Our ref: 2270096A-ENV-LTR-001 RevA

**SSD 6471 – SYDNEY MODERN – ART GALLERY OF NSW – RESPONSE TO SUBMISSIONS
(RtS) REPORT- MARINE IMPACT ASSESSMENT**

I am writing to you in reply to comment “a” by the Environment Protection Authority on the seawater heat exchange system proposed in the RtS report concerning the above project. The comment and recommendation is reproduced below:

Fig 8.0A – Proposed location of intake and discharge points

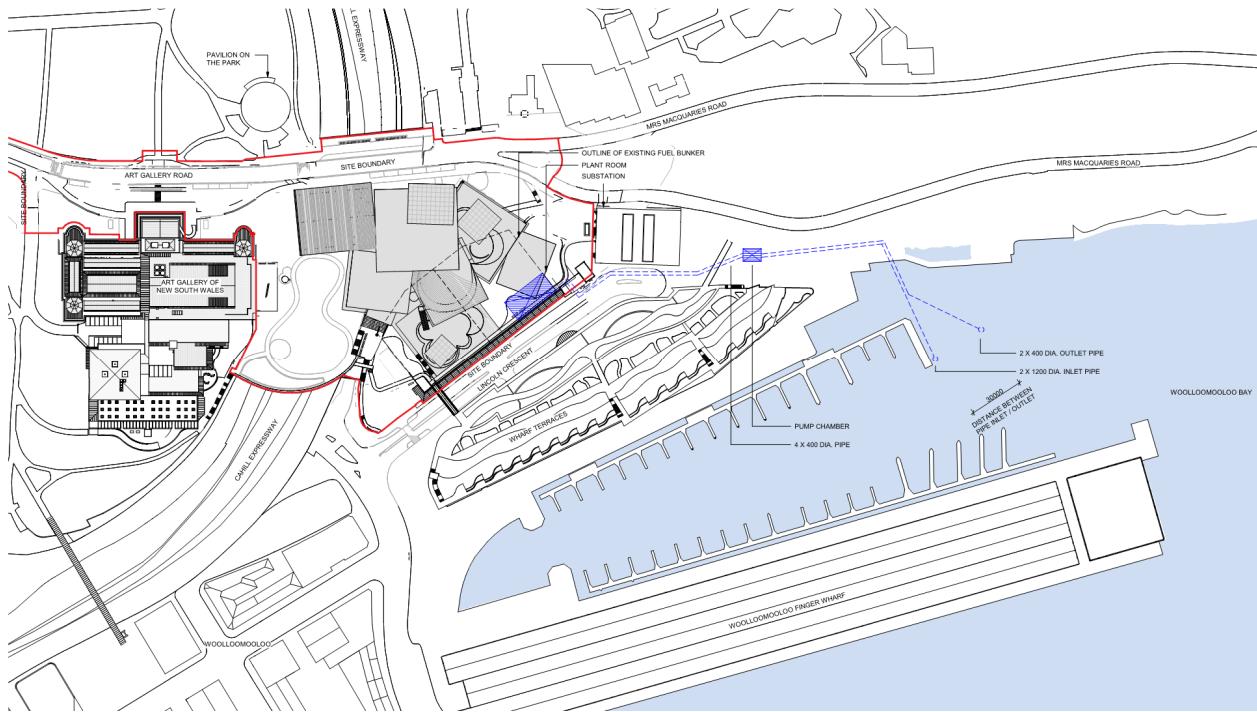
The EPA notes that the design of Seawater Heat Exchange System described in Appendix H to the Report appears different to the design described in the related document accompanying the EIS, including an increase of:

- *net heat rejection capacity from 1,600 to 2,600 kilowatts (~60% increase); and*
- *twin outlet pipe diameter from 300 to 400 millimetres*

The EPA notes that the EIS states that the outlet pipe design diameter is 300 millimetres, however the modelling assumes a pipe diameter of 400 millimetres as a worst-case scenario.

The proponent be required to provide a revised assessment that clearly shows the predicted impact of the increased net heat rejection capacity and revised discharge design on the receiving waters of Sydney Harbour, including a detailed analysis of the extent of the thermal plume with reference to the existing modelling (or revised modelling should existing modelling no longer be representative of the amended seawater heat exchange system design).

It is proposed that the return seawater is conveyed via a 400mm pipe back to the ocean. This pipe size is designed to accommodate a discharge water flow rate of 117L/s, with a thermal capacity of 2,600kW.

The modelling of the heat plume dispersion was performed using a flow rate of 117L/s and a 400mm discharge pipe. The extent and persistence of the heat plume introduced into the Bay under this design is considered within the modelling report and the Marine Impact Assessment.

The modelling and impact assessment are consistent with the proposed design and as such, any updates or changes are unnecessary.
